Rear single storey extension to form summer house & minor alterations to existing structure to include shower room. This application affects the character and appearance of Arundel Conservation Area

43 King Street Arundel

Thank you for your internet representation made on 29th July 2014 which has been recorded as '**an objection**' with the comments as follows:

The following comments are in respect of the latest drawing from Stride and Son no. 13151-02-B.

DRG. No.	13151-02 B
SCALE	1:50
DATE	November 2013
DRAWN	SR
CHECKED

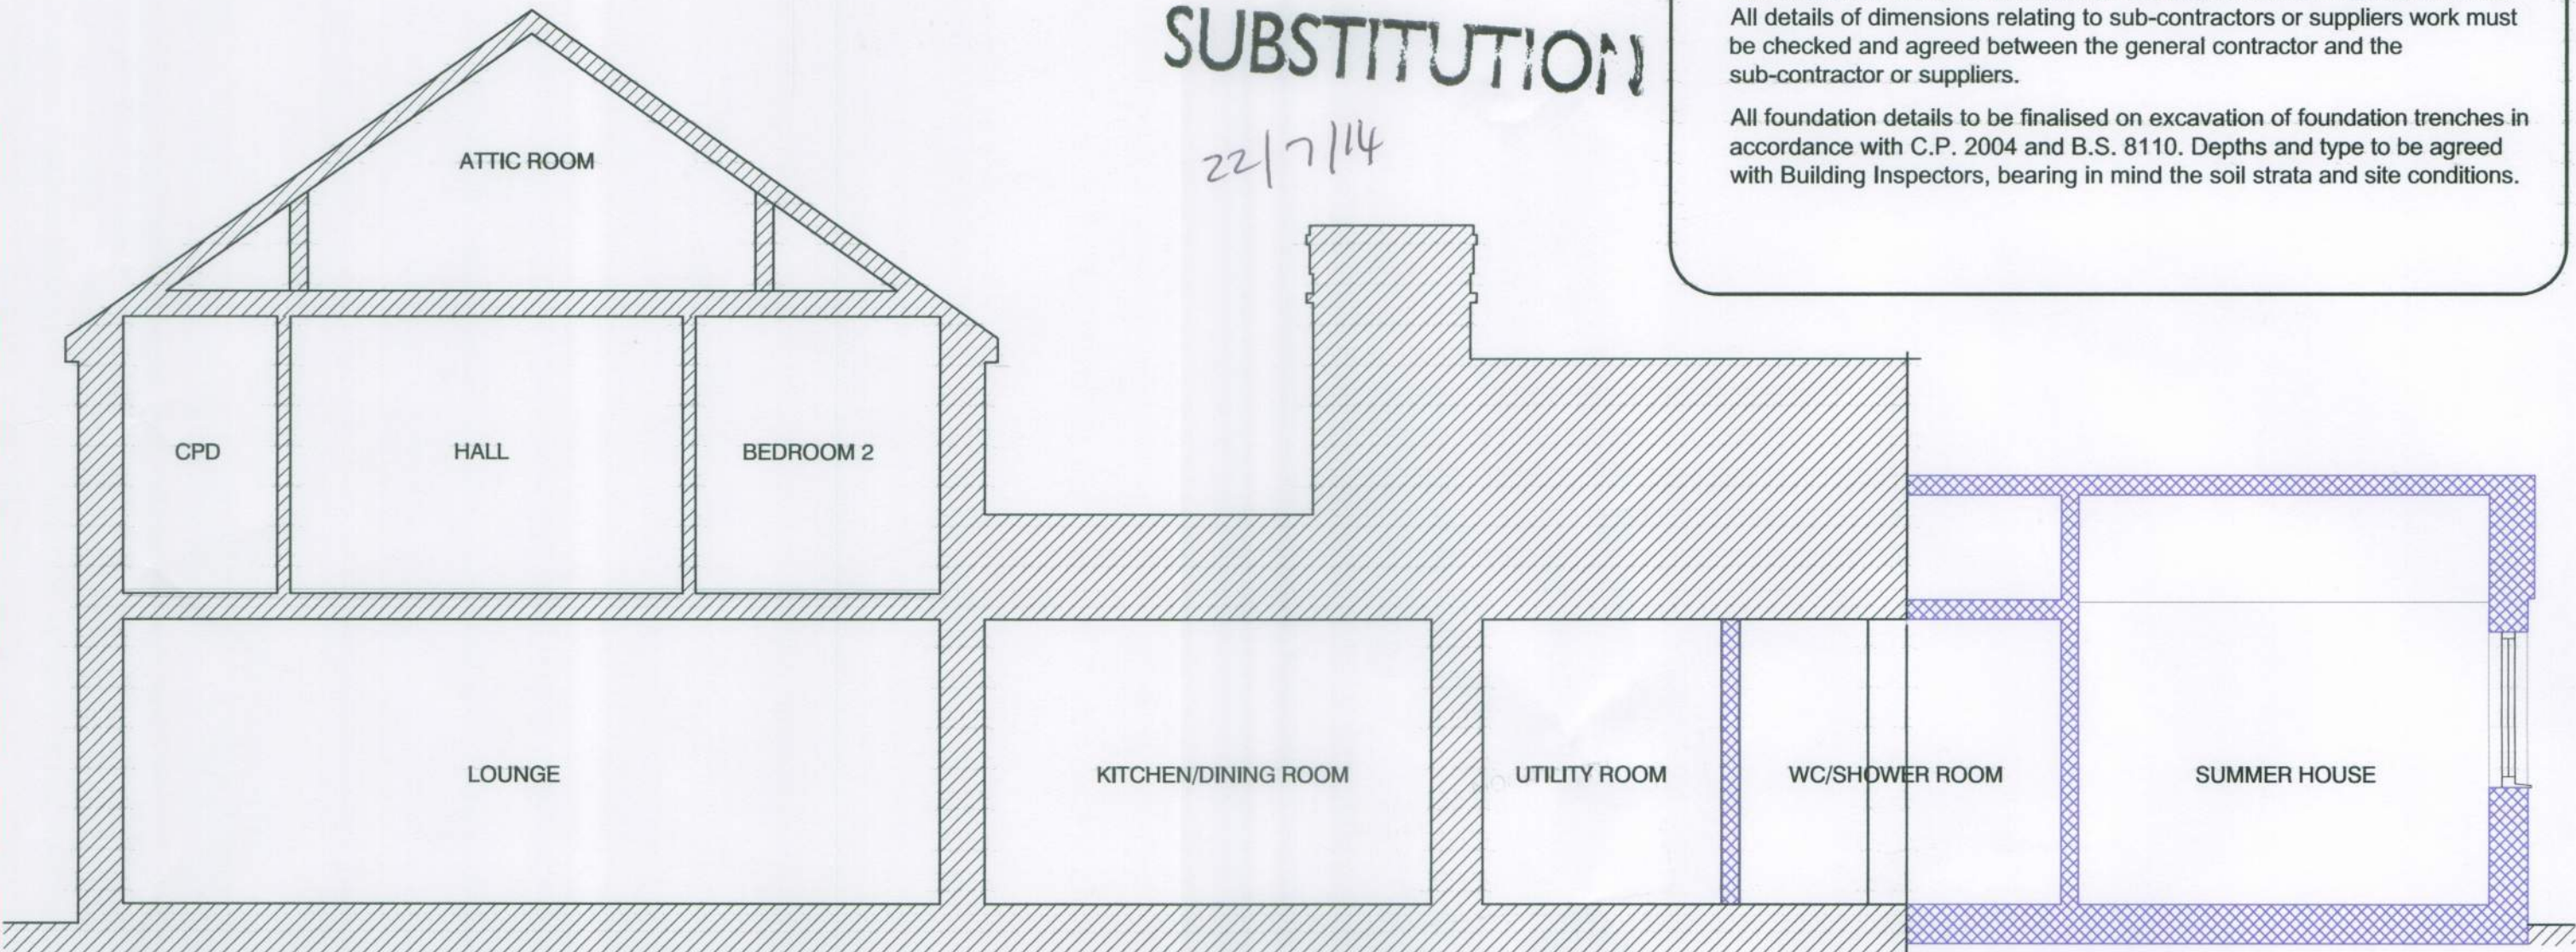
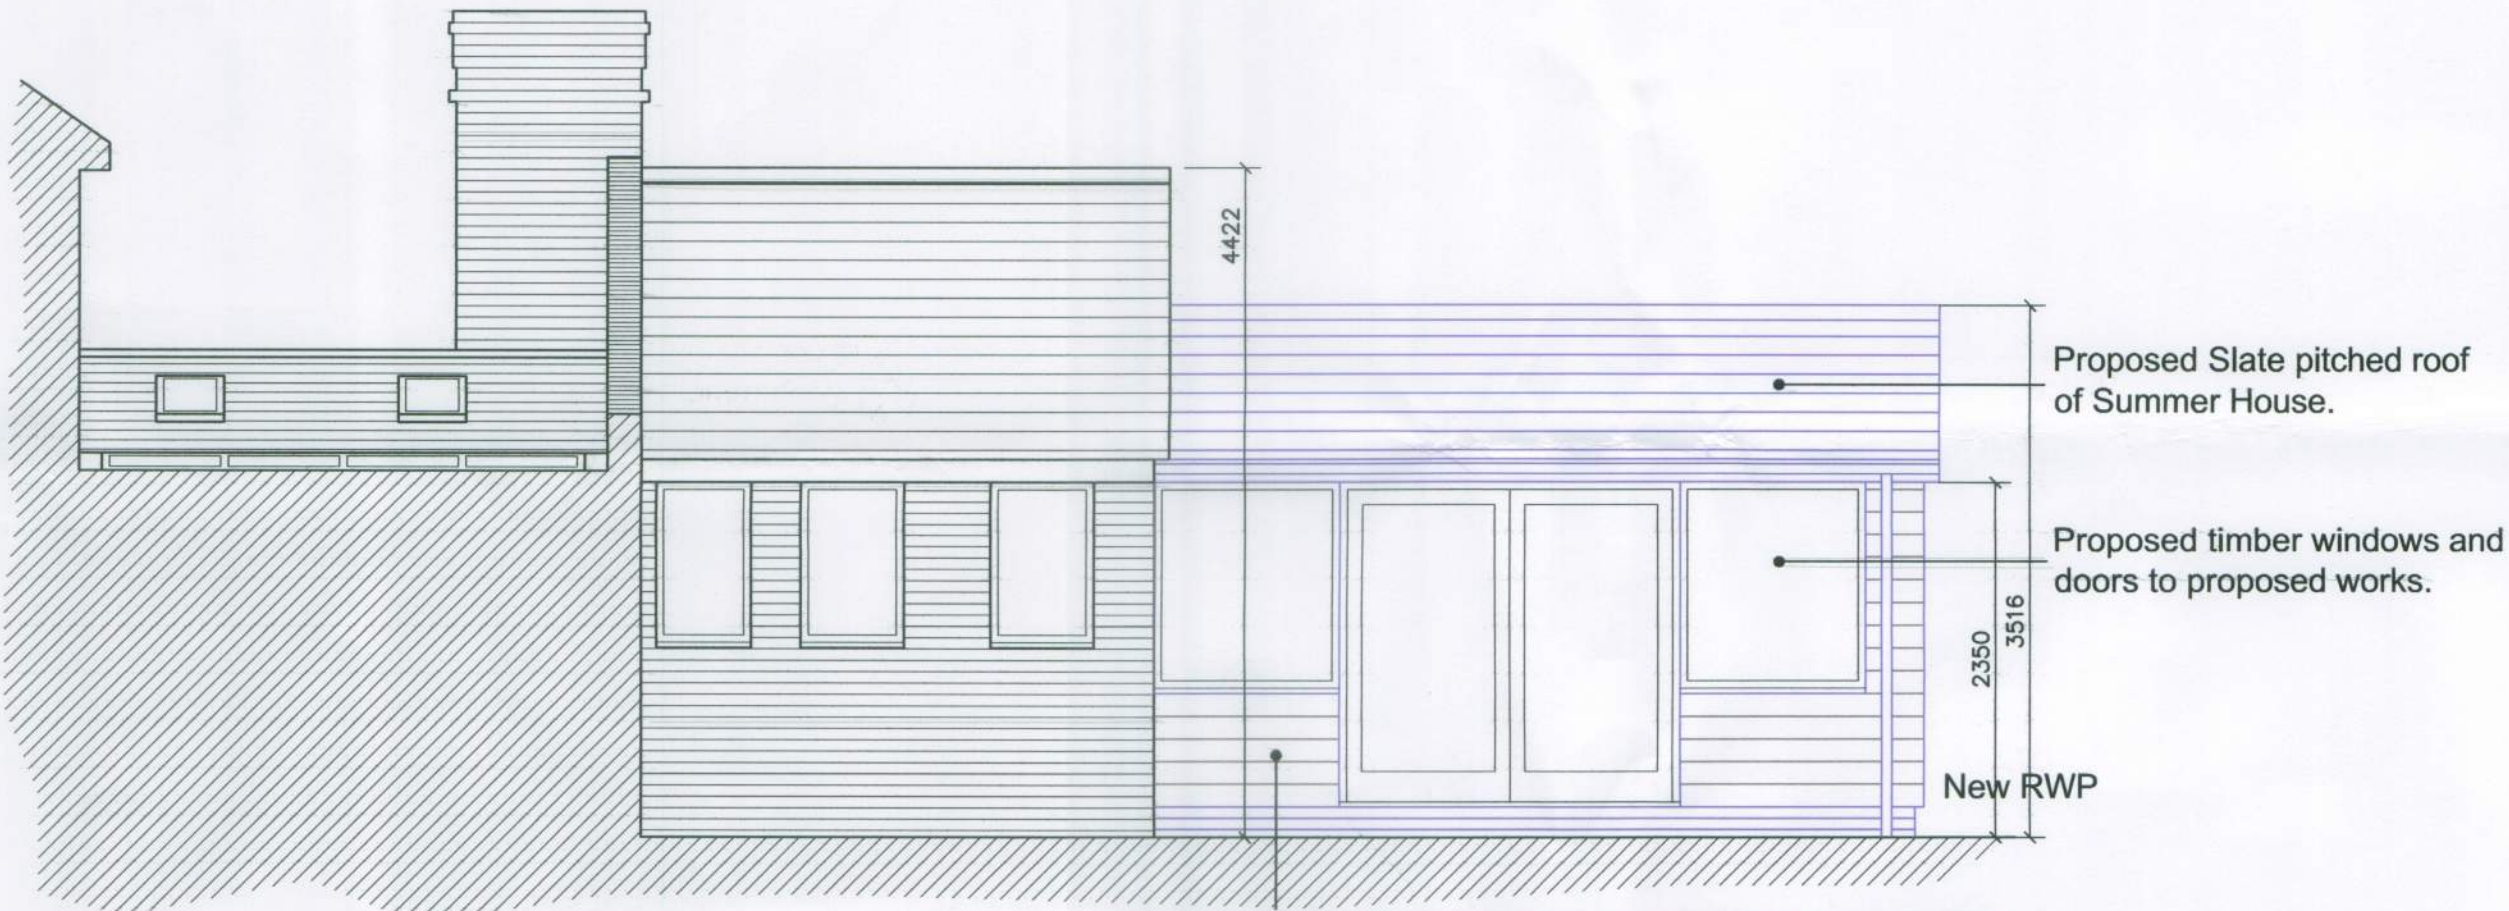
I still object to the height shown on that drawing and to the length (not shown, but calculated from the scale of 1:50).

However, last night, 28 July, I met Mrs Palmer and her builder and we three provisionally agreed the following dimensions:-

- 1. Maximum height (to the apex of the roof from ground level) - 2.5 metres.*
- 2. Maximum length (from the rear wall of the existing 19th century structure - 4.3 metres - but subject to...*
- 3. The roof line to fall away on the western side after 3.5 metres with a hip end.*

These critical measurements are to be enshrined in any planning consent that may be granted.
